DECISION DELEGATED TO DEVELOPMENT MANAGER

Application No: H17-0504-19 **Applicant:** Mr M & Mrs J Bennett
Proposal: Erection of dwelling - Outline approval H17-0242-17
Location: Off Stockhouse Lane Surfleet Spalding
Terminal Date: 9th September 2019

Job Title		Date		Drawn by	
Proposed Dwelling		May 2019		GG	
Land adj. 23 Stockhouse Lane				Checked by	
For Mr & Mrs Bennett				GE	
Drawing Title		Job No.		Sheet Size	
Planning Drawing		SE-1163		A1	
Ground Floor Plan,		Drawn by		Revision	
First Floor Plan,		PP1100		02	
Section and Elevations

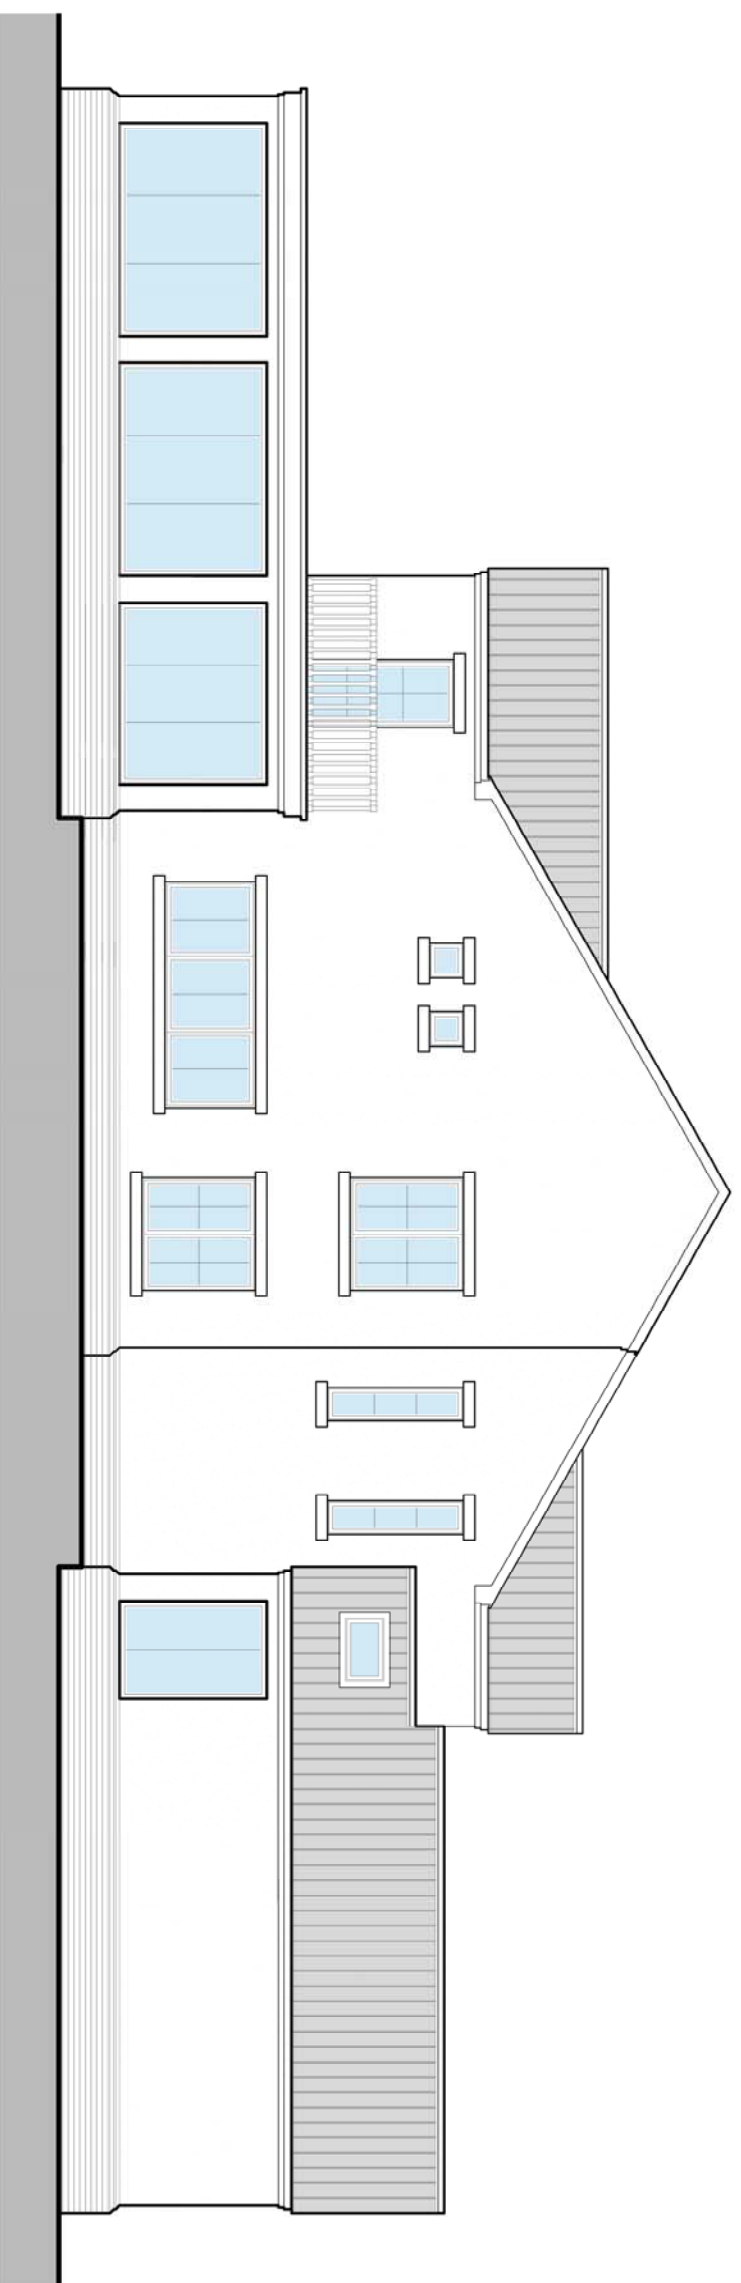
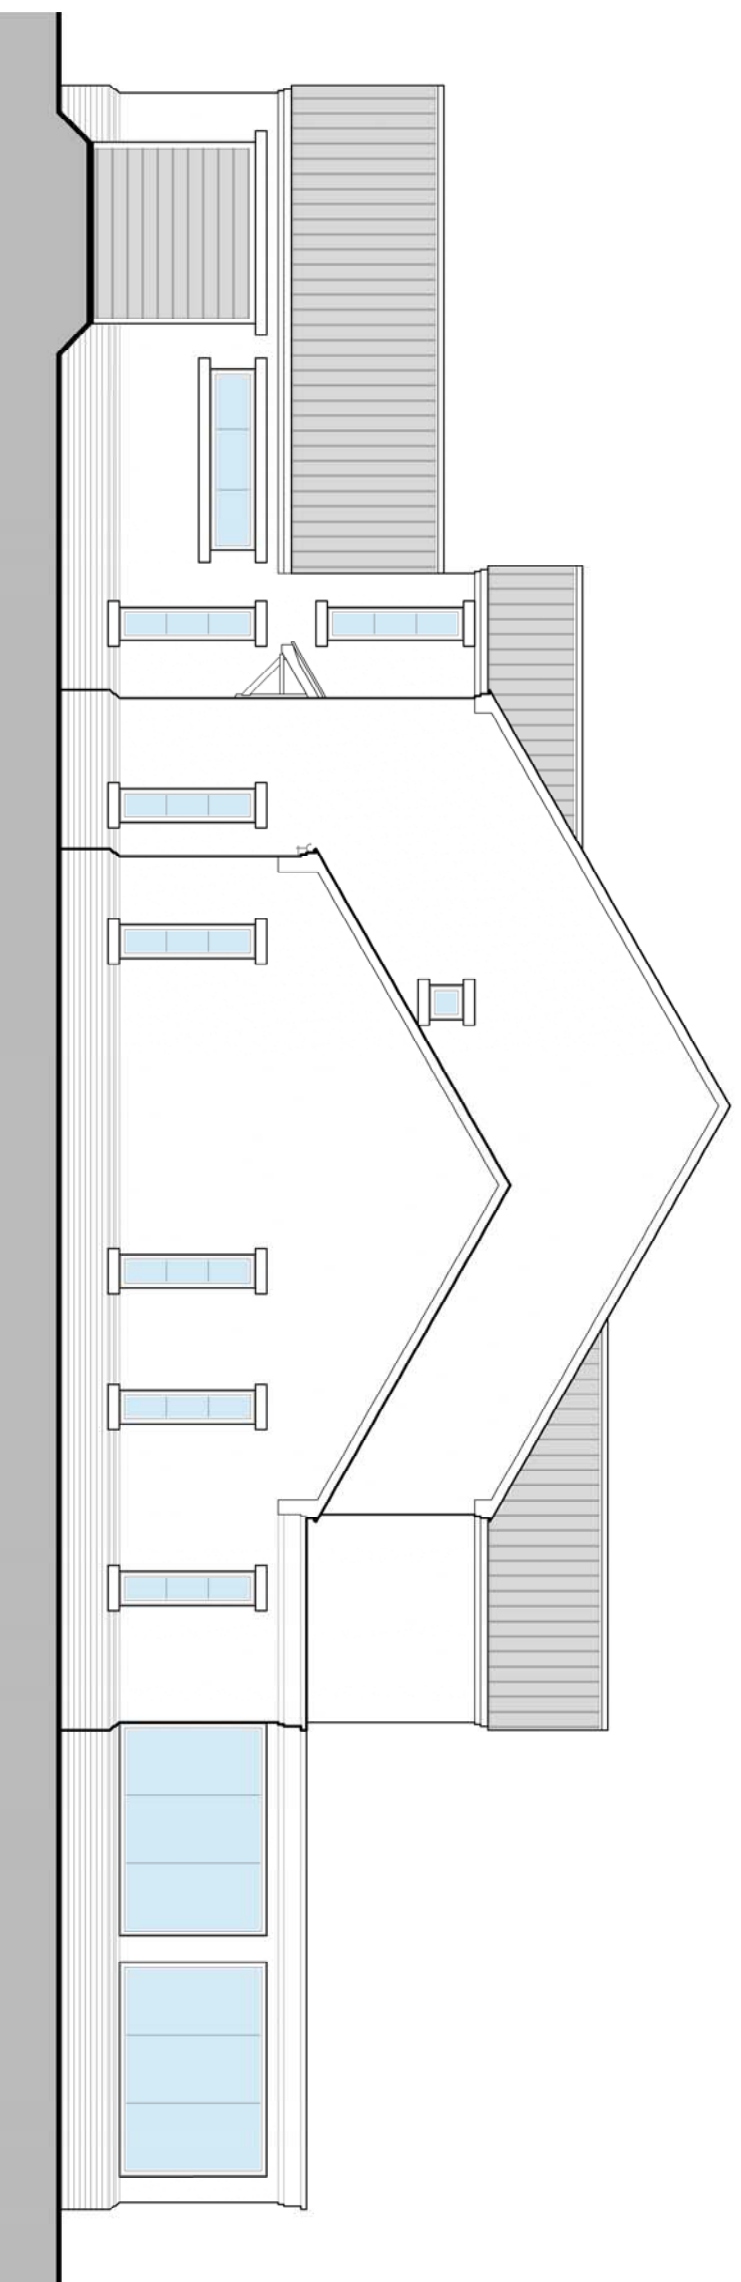
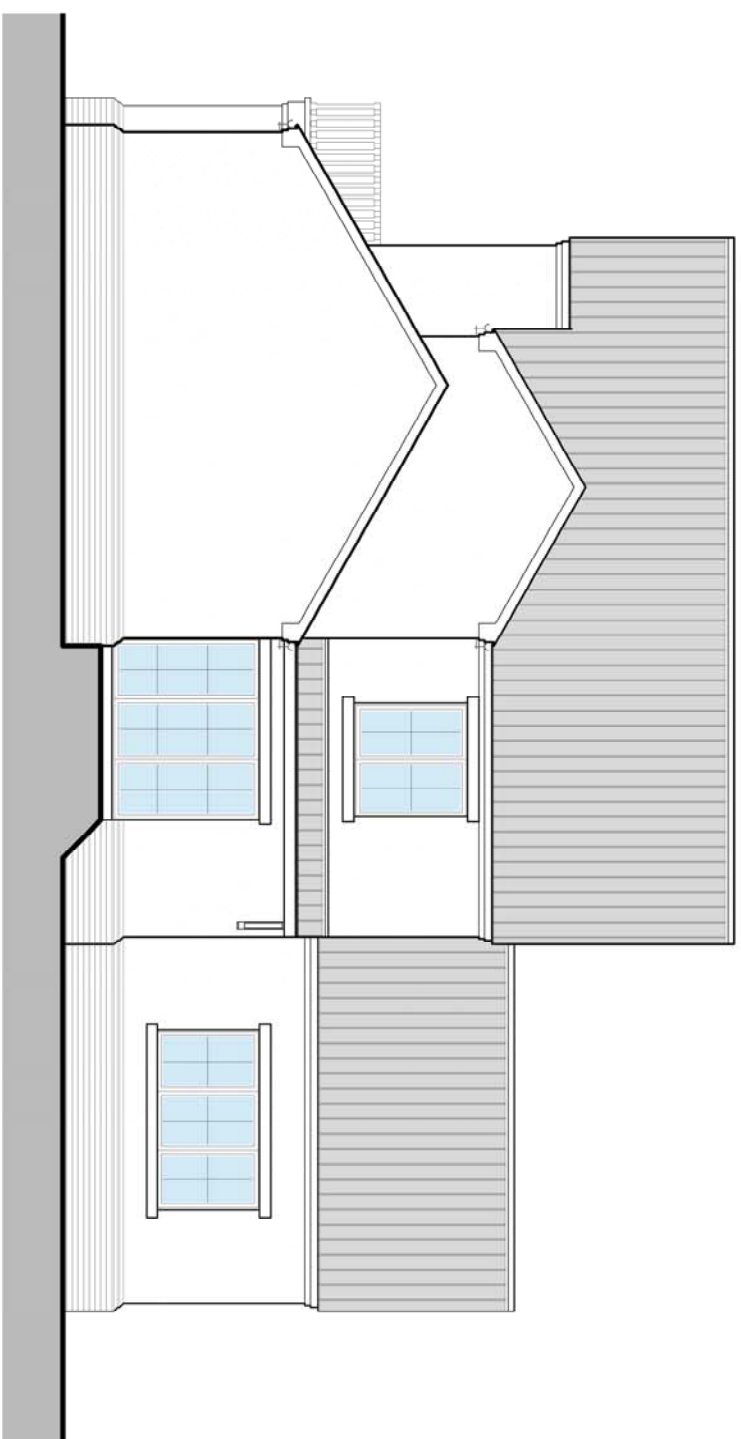
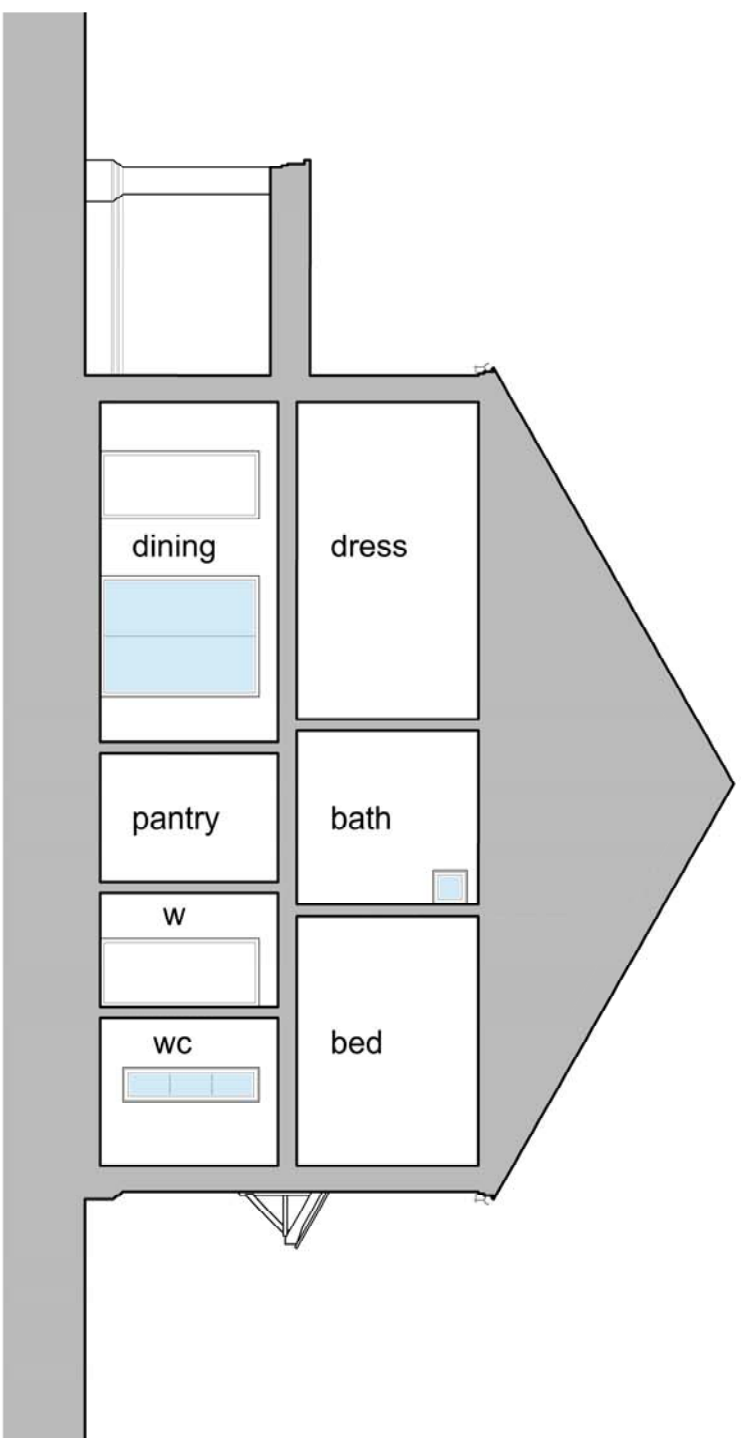
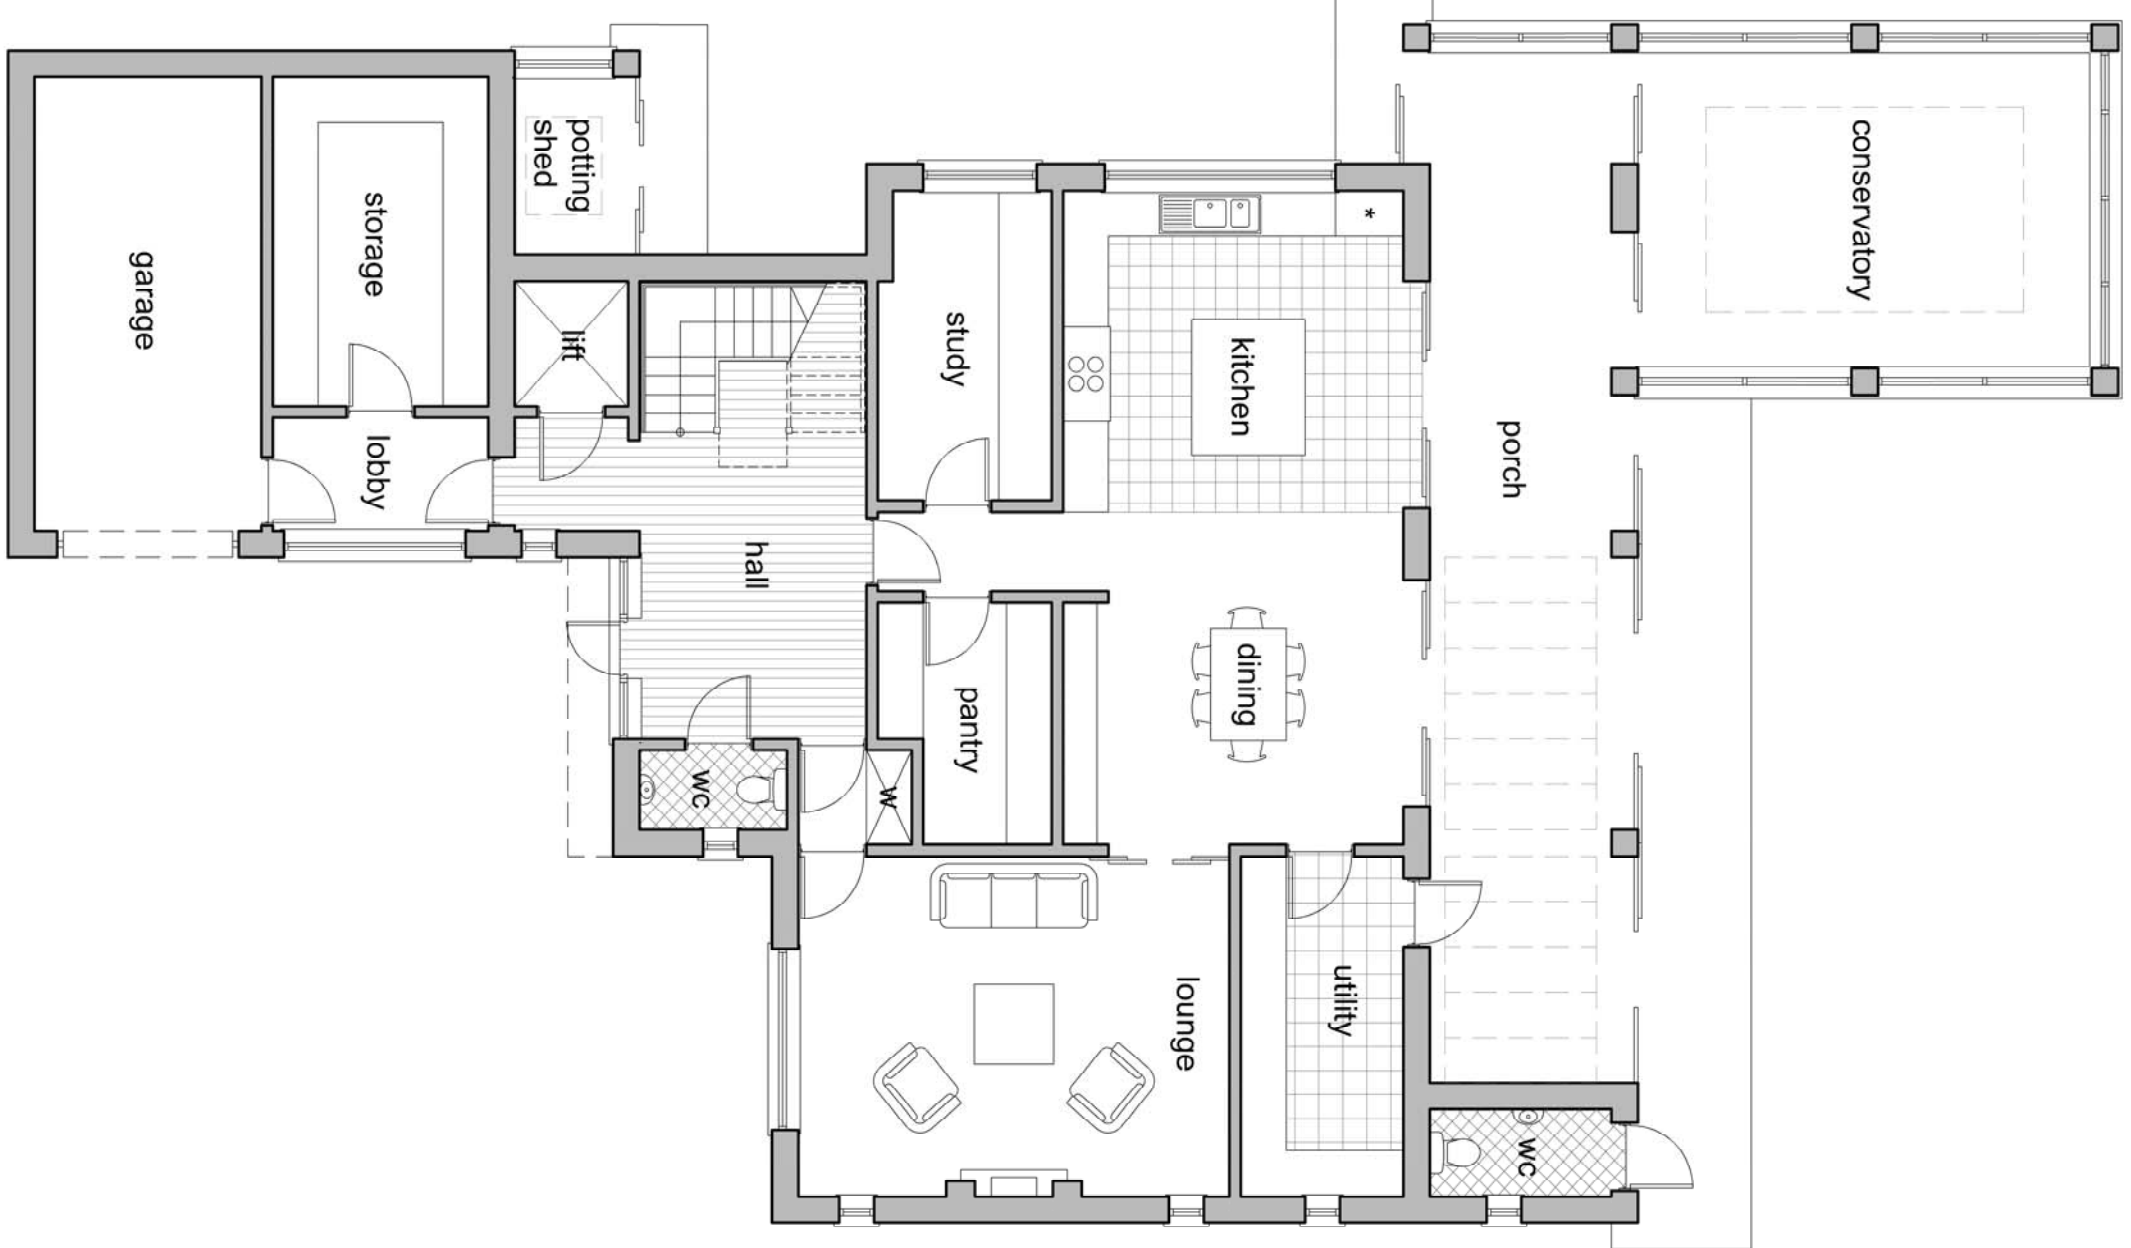
Following negotiations with the case officer the scheme has been amended and reduced in size from the original submission which was felt to be too large for the plot. Some of the massing of the property was in the single storey elements but it was felt to be too dominant and not at all in keeping with the plan submitted in support of the outline application.

The proposed dwelling even with amendment remains the antipathy of the Outline approval. The proposed house is a high solid block of integrated building which almost fills the plot and appears to have a footprint equal in size the adjacent homes put together. The design makes no attempt whatsoever to blend or reflect the overall nature of the surrounding properties which in this part of Surfleet are predominantly bungalows and cottages. It is totally out of keeping and will not enhance but dominate.

I strongly object to the proposed building/planning application because it in no way equates to the original approved outline planning application (H17-0242-17) which was for a chalet bungalow with detached garage and landscaping. The proposed house can in no possible way be described as a chalet bungalow and all the building is integral - its one big block of building with little landscaping disproportionate in size not only to the plot but to the adjacent bungalows and cottages in Stockhouse Lane, and in no way attempts to 'blend' or relate to the surrounding open countryside. In the original application the site was described as 'not visible' from the road, the house will not only be visible it will dominate. If this application is approved I find it makes a sham of the outline planning process.

The original submission plans for this Reserved Matters Application were for a dwelling that was considered excessive in size and not appropriate for the plot, nor did it reflect the (albeit indicative) Outline Planning Permission.

The design, size and scale including massing on the plot has all been revised by the Agent and the resultant scheme is more modest and more appropriate in its size and scale.

Following negotiations the Agent has re-designed a more appropriately sized dwelling which is now acceptable.

The design is acceptable and the amendments made by the Agent overcome the original concerns.
